Application No: EP/126/20/HH
Site Address: 56 Angmering Lane East Preston BN16 2TA
Description of works: Resubmission (EP/37/20/HH) of proposed extensive refurbishment of existing 2-storey dwelling to include, single storey side/rear extensions, 2-storey rear extension, roof extension and front double garage

This council's Planning & Licensing Committee considered this Application at its meeting on Monday, 9th November.

The committee has agreed to object to this Planning Application as it believes it is contrary to the Arun Local Plan and the East Preston Neighbourhood Plan.

Paper Size:	A1	Date:	Oct. 2020
Job Number:	Drawing Number:	Revision:	
	07	A

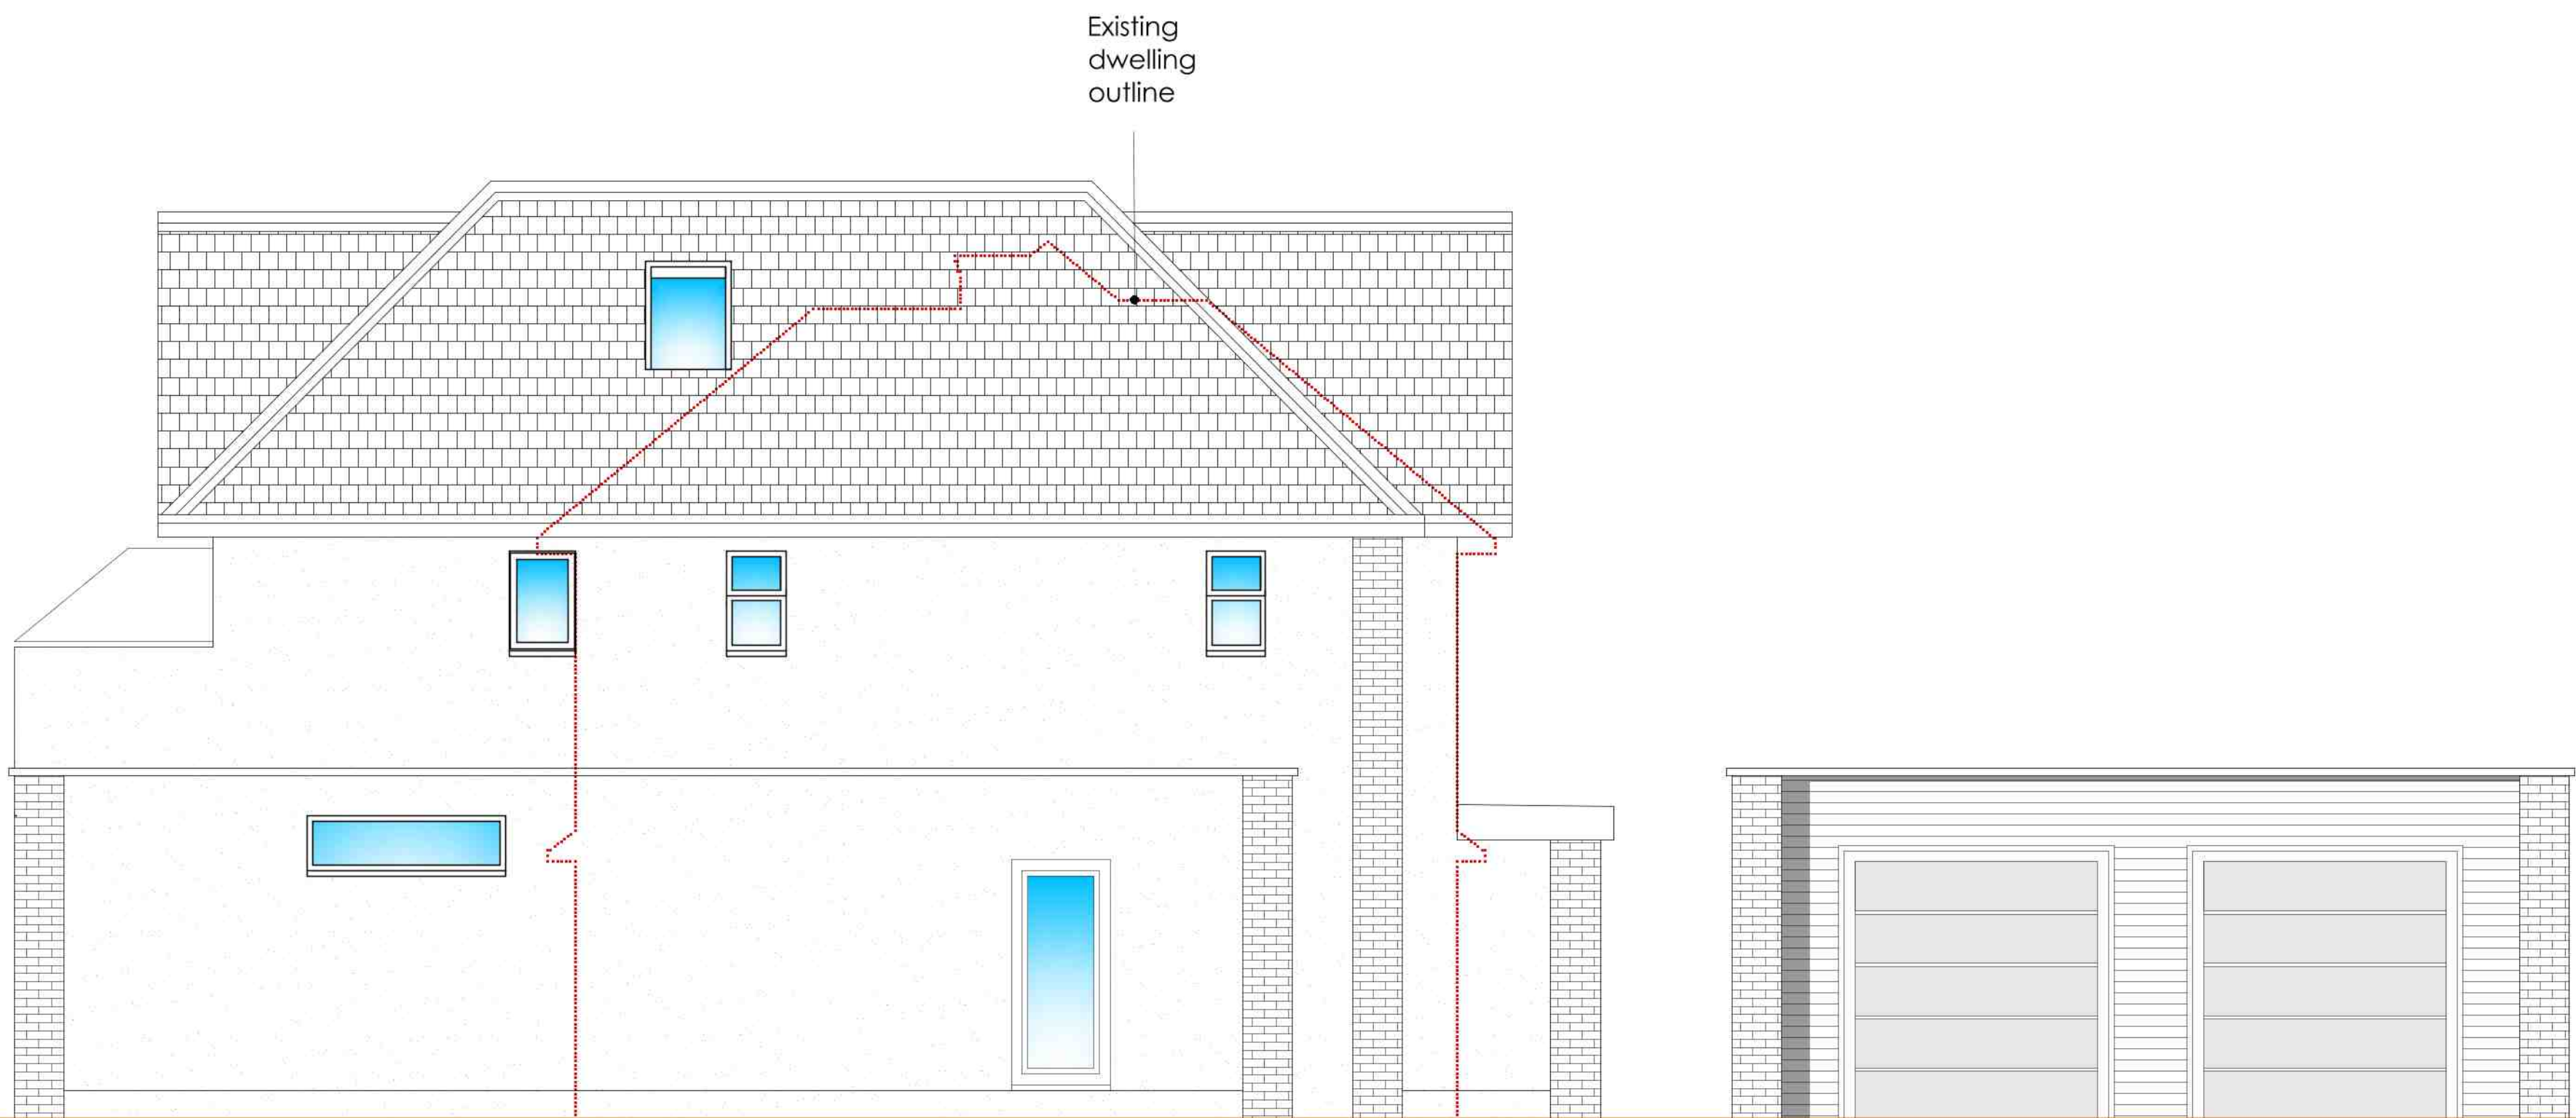
The proposal also conflicts with Policy D DM4 as it does not sympathetically relate to nor is it visually integrated with the existing building in massing, design, form scale and materials. Equally, the extension,

when viewed from the north or the south, could not be considered visually subservient to the main building.

Job Number: Drawing Number: 05 Revision: A

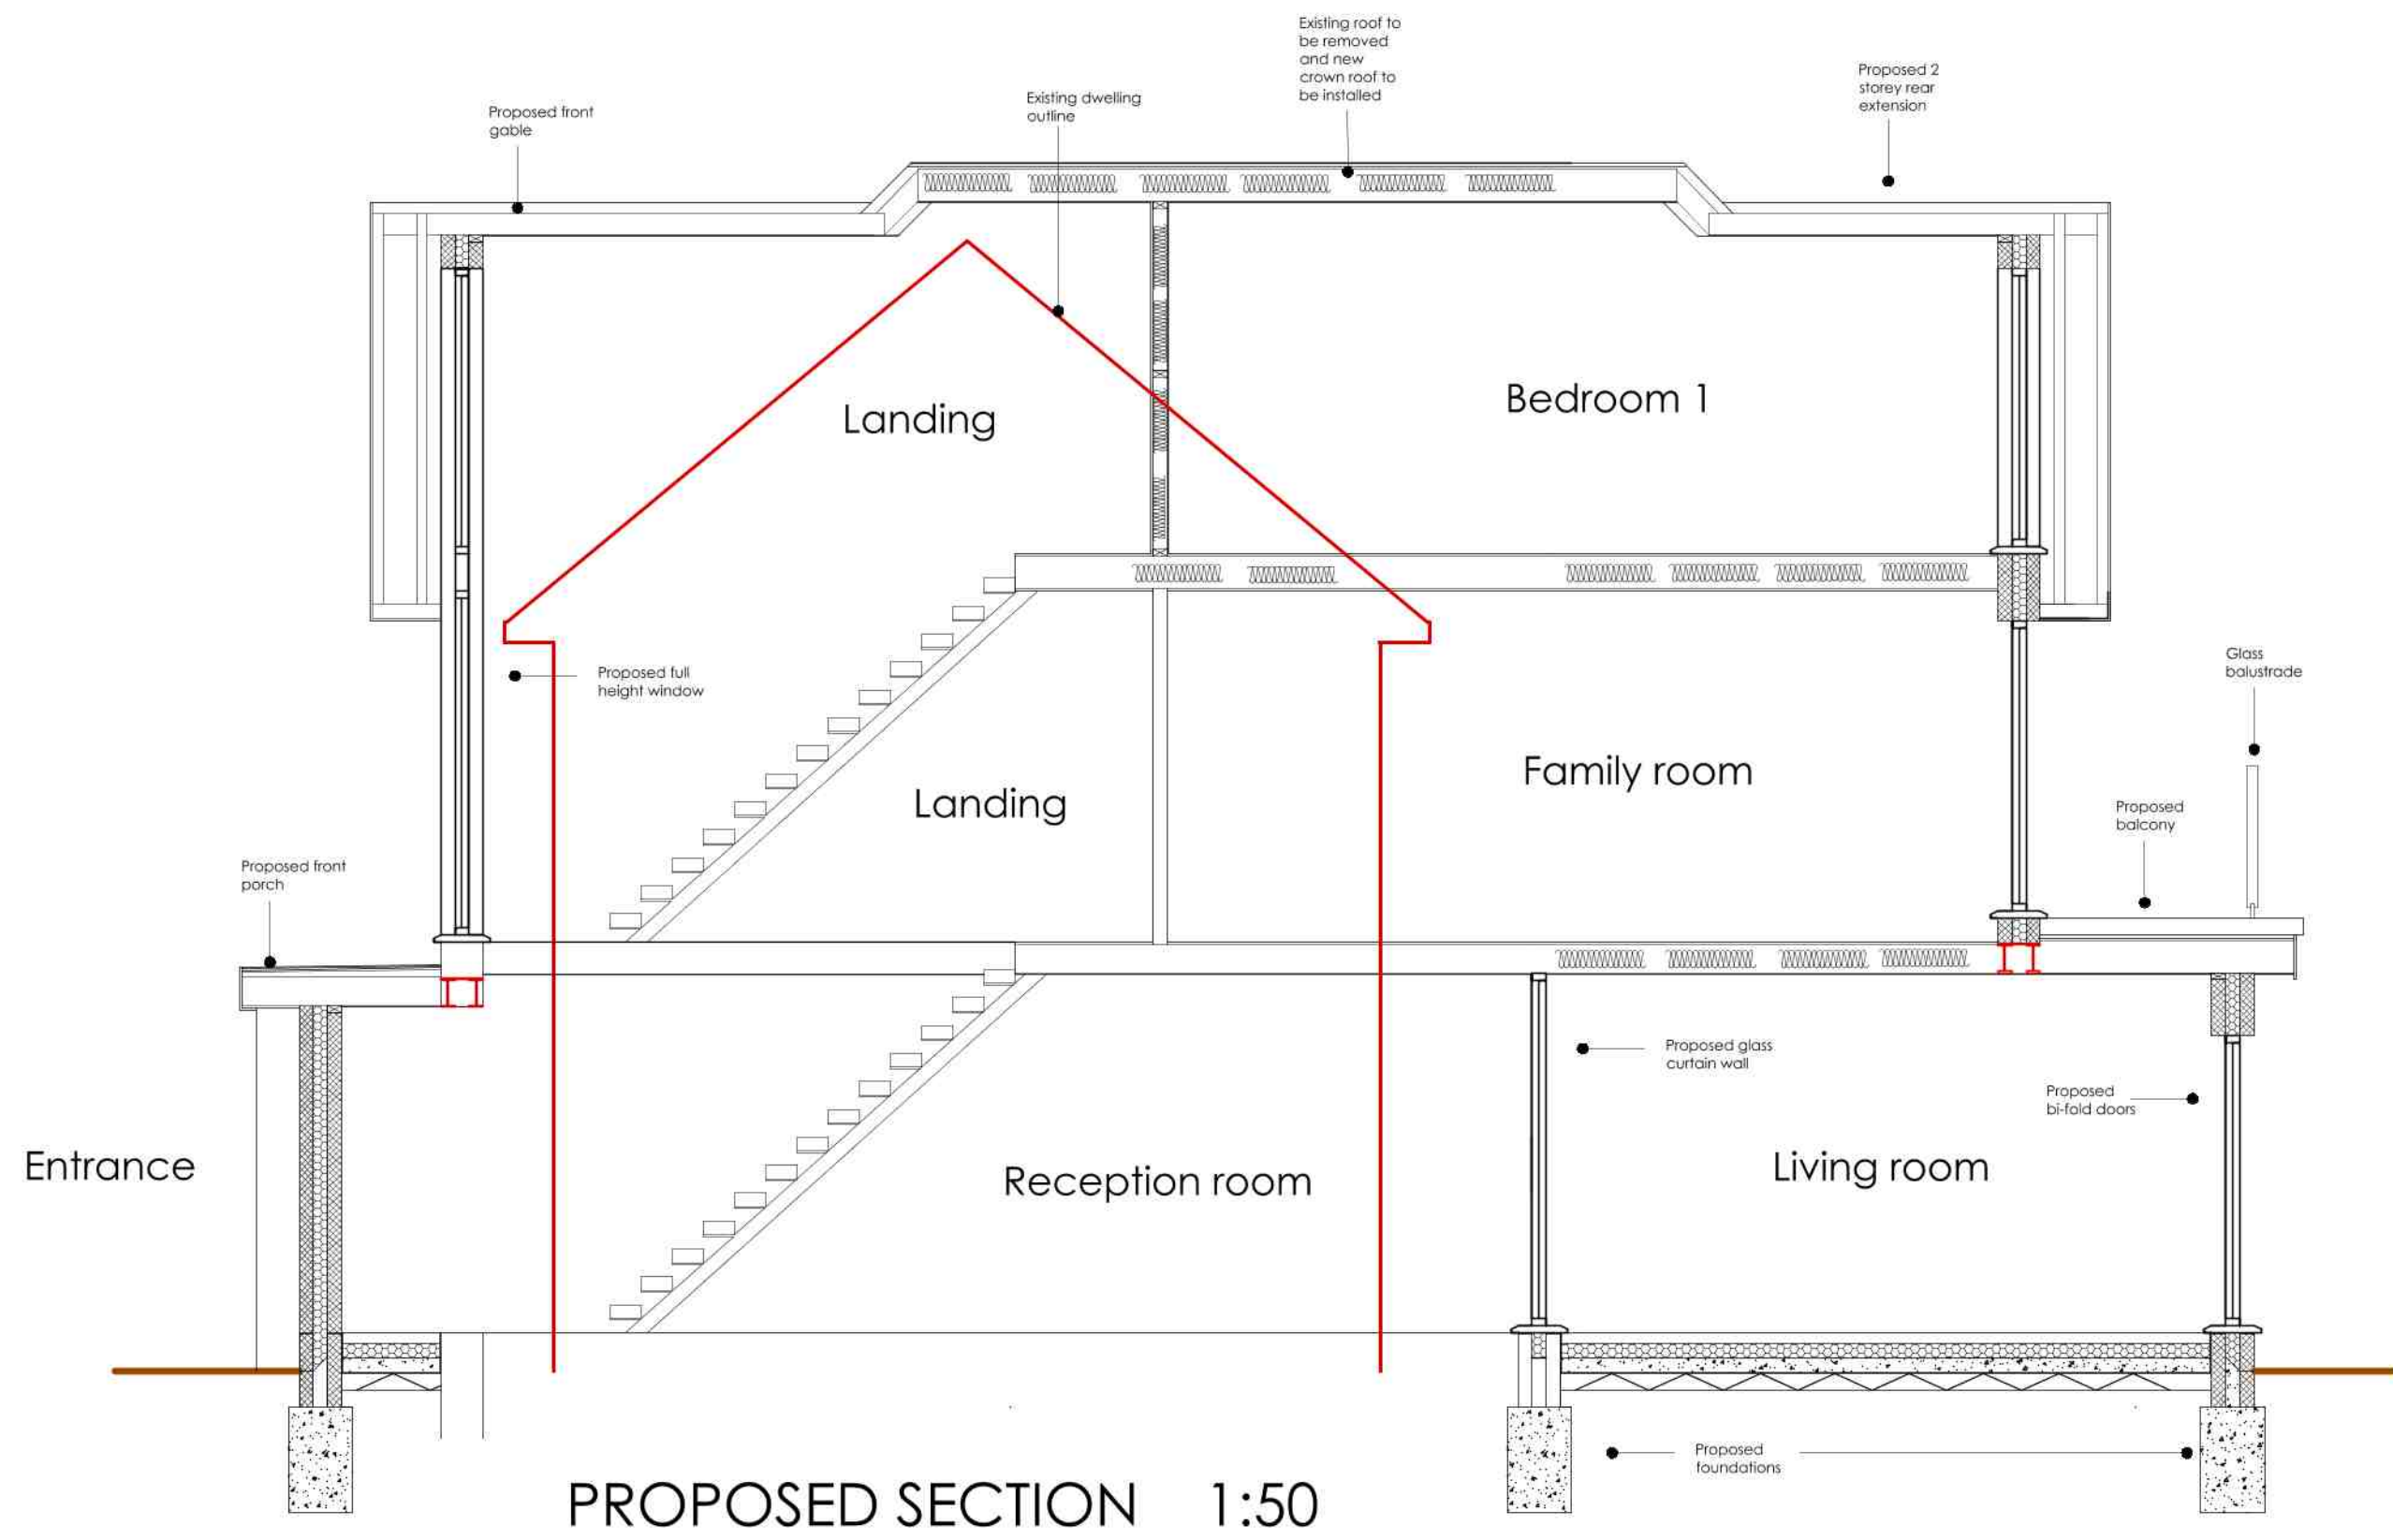
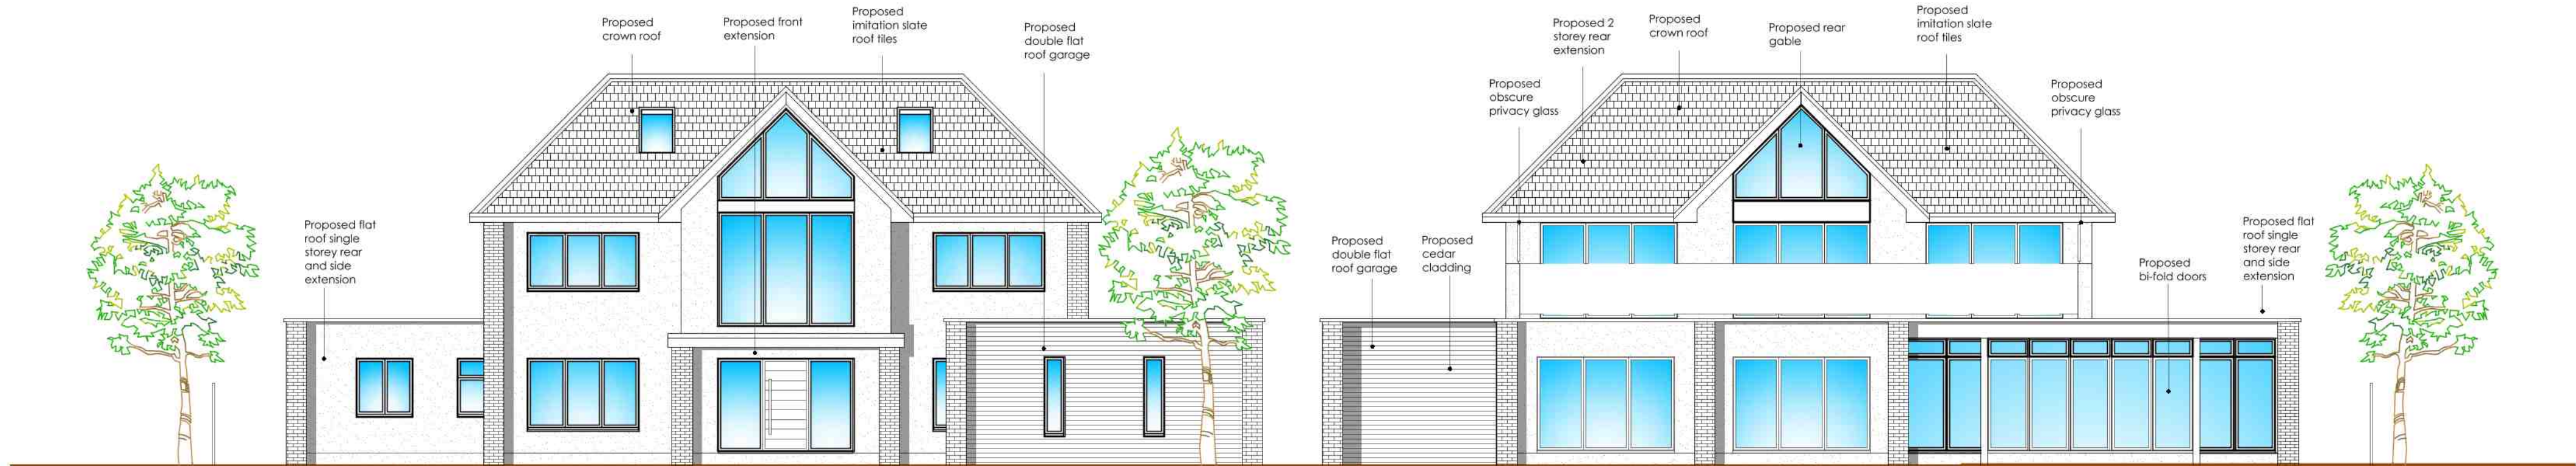
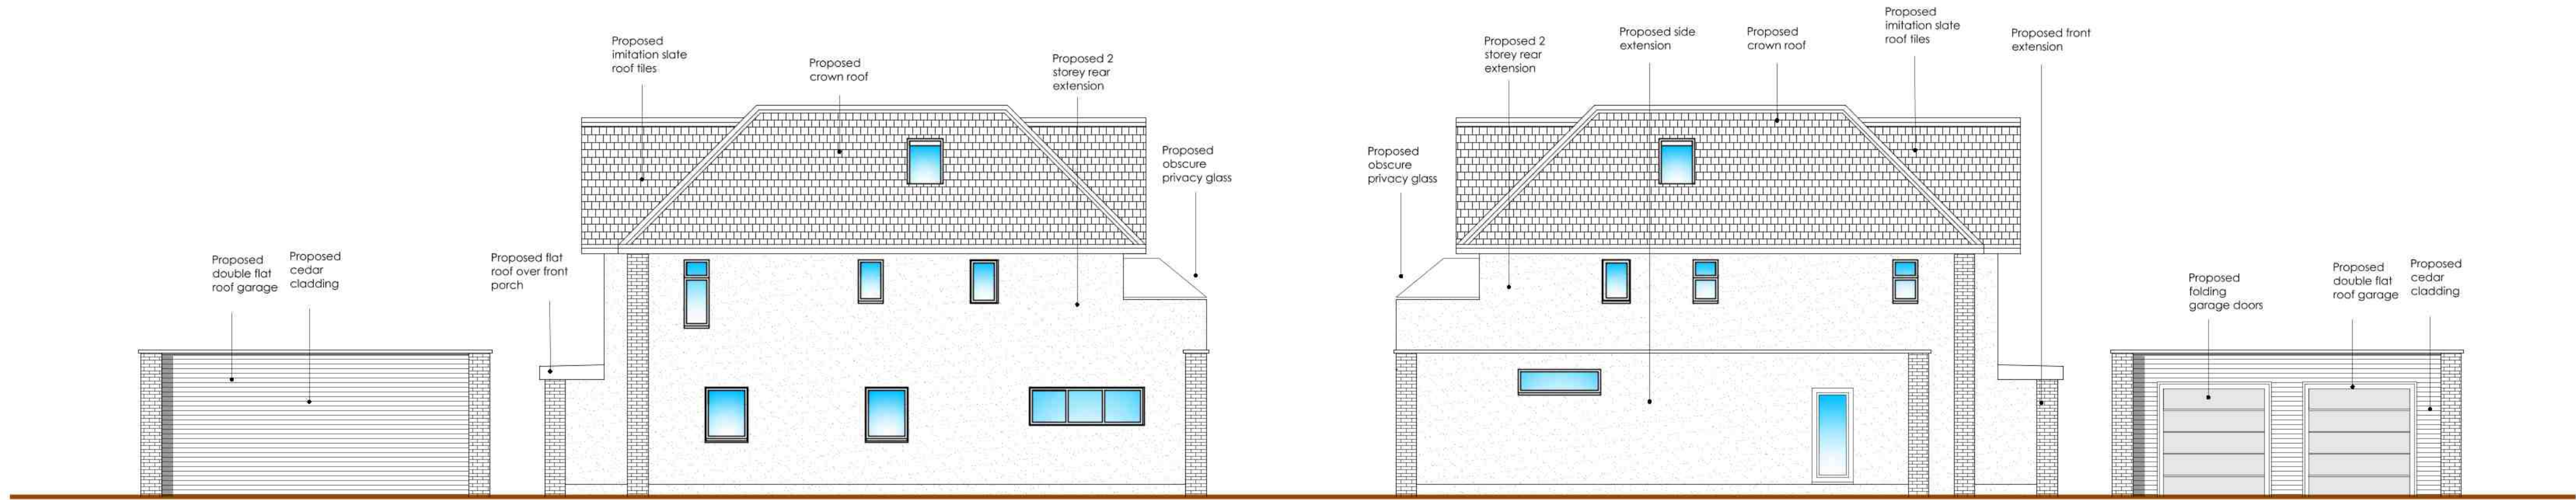
Paragraph 4.14 of the East Preston Neighbourhood Plan states New or altered buildings that exceed two storeys in height will rarely be acceptable. The proposed redevelopment includes an increase in the height of the property which may appear minimal, but the proposed design of the top storey will result in a property looking much higher. The resulting property will be out of keeping with the street scene and unneighbourly. The addition of windows in the proposed second storey will directly and unacceptably remove the existing privacy of neighbouring properties. There seems to be no mention of obscured glazing in this proposal.

Paragraph 4.16 of the East Preston Neighbourhood Plan states, Extensions should be designed to look as if they were part of the original design of the house. The proposed redevelopment of 56 Angmering Lane, still described as an extensive refurbishment , does not look part of the original design of the house. It is wholly out of character with the properties surrounding it. Angmering Lane is a mix of architectural styles built up over a number of decades, but all are based in traditional brick and stonework. The proposed amount of statement glazing would perhaps be suitable for a site facing the beach, but this is not such a site.
